State of Washington
DEPARTMENT OF FISH AND WILDLIFE

SUBJECT: WDFW COMMENTS ON CU-21-00003 Ryegrass LPL Expansion

FIGURE
 2-1

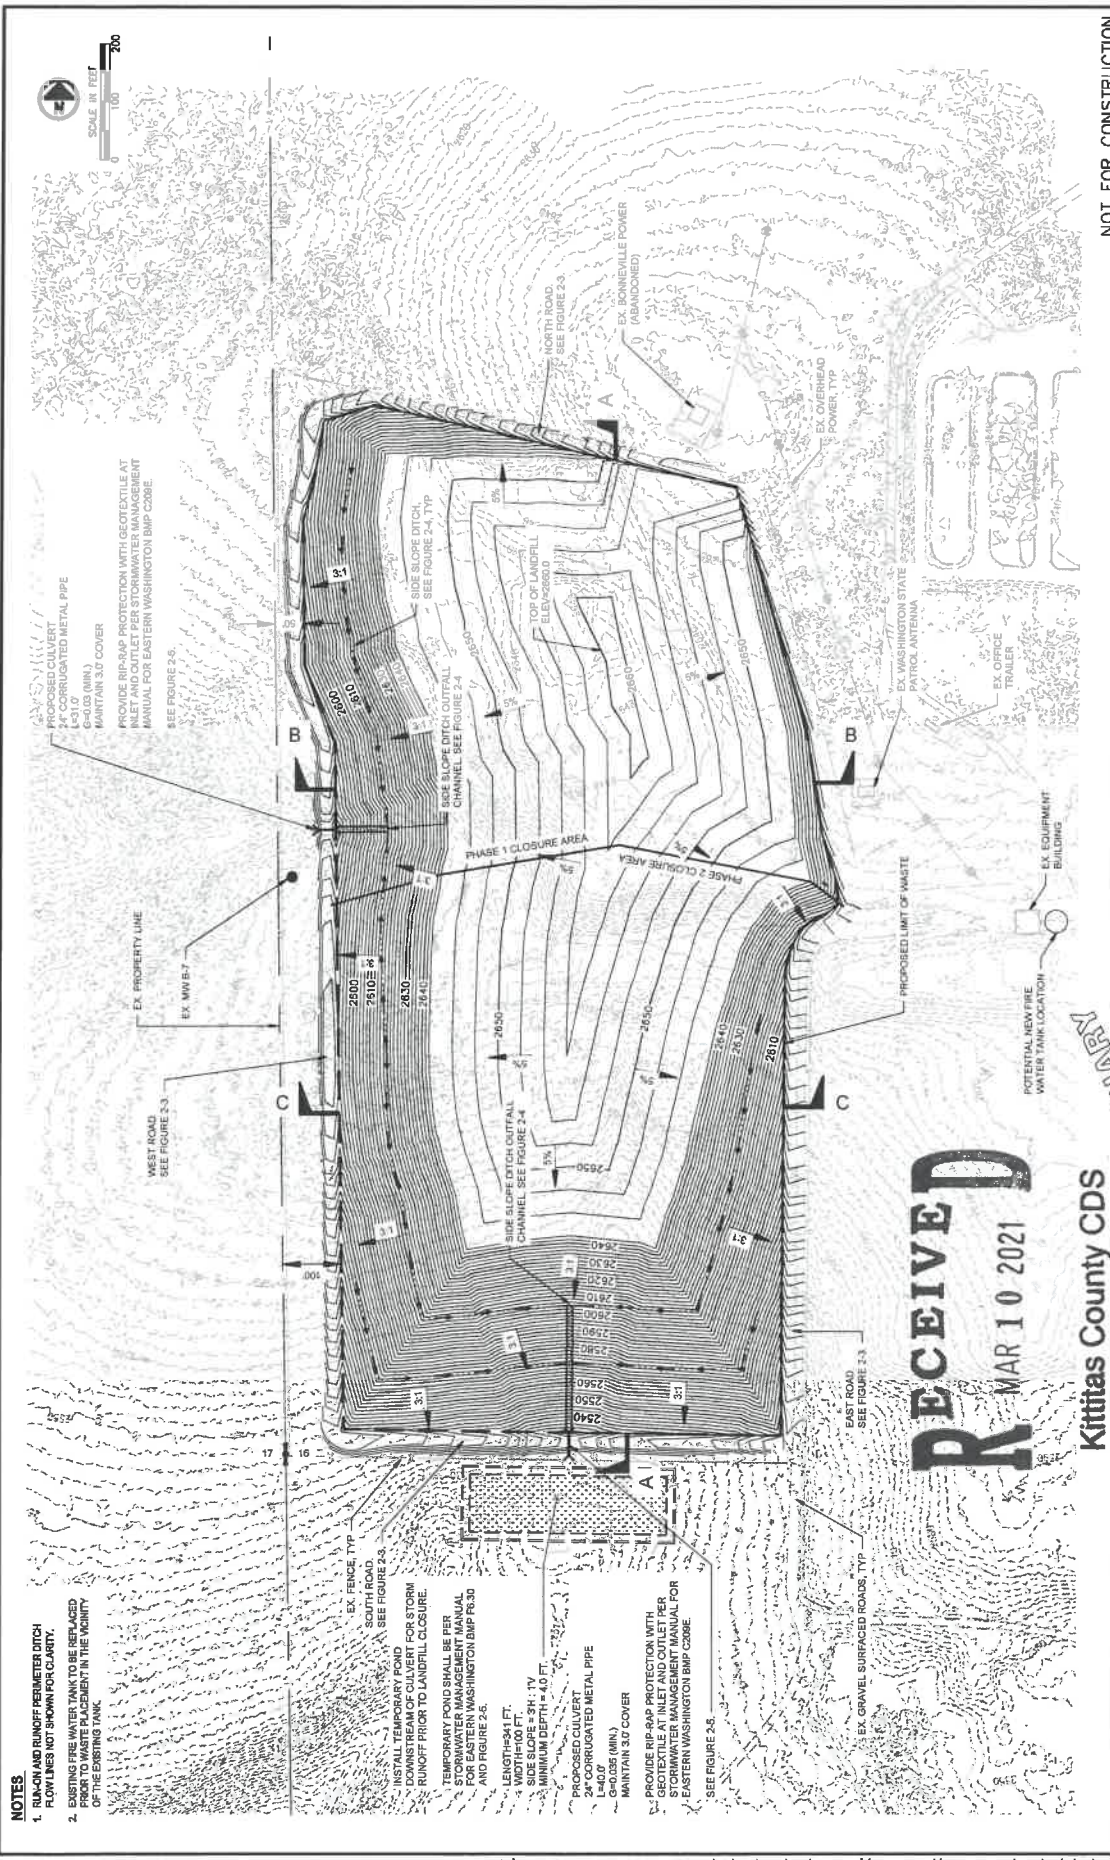
While it appears that some of the expanded footprint is in previously disturbed areas, some of the project areas do appear to include shrubsteppe habitats. WDFW would like to request that the mitigation measures registered with SE-20-00009 should also be applied to this proposal and that WDFW should meet with the applicant to find ways to avoid existing sagebrush areas and in areas that are unavoidable, mitigation opportunities to restore other areas into sagebrush.
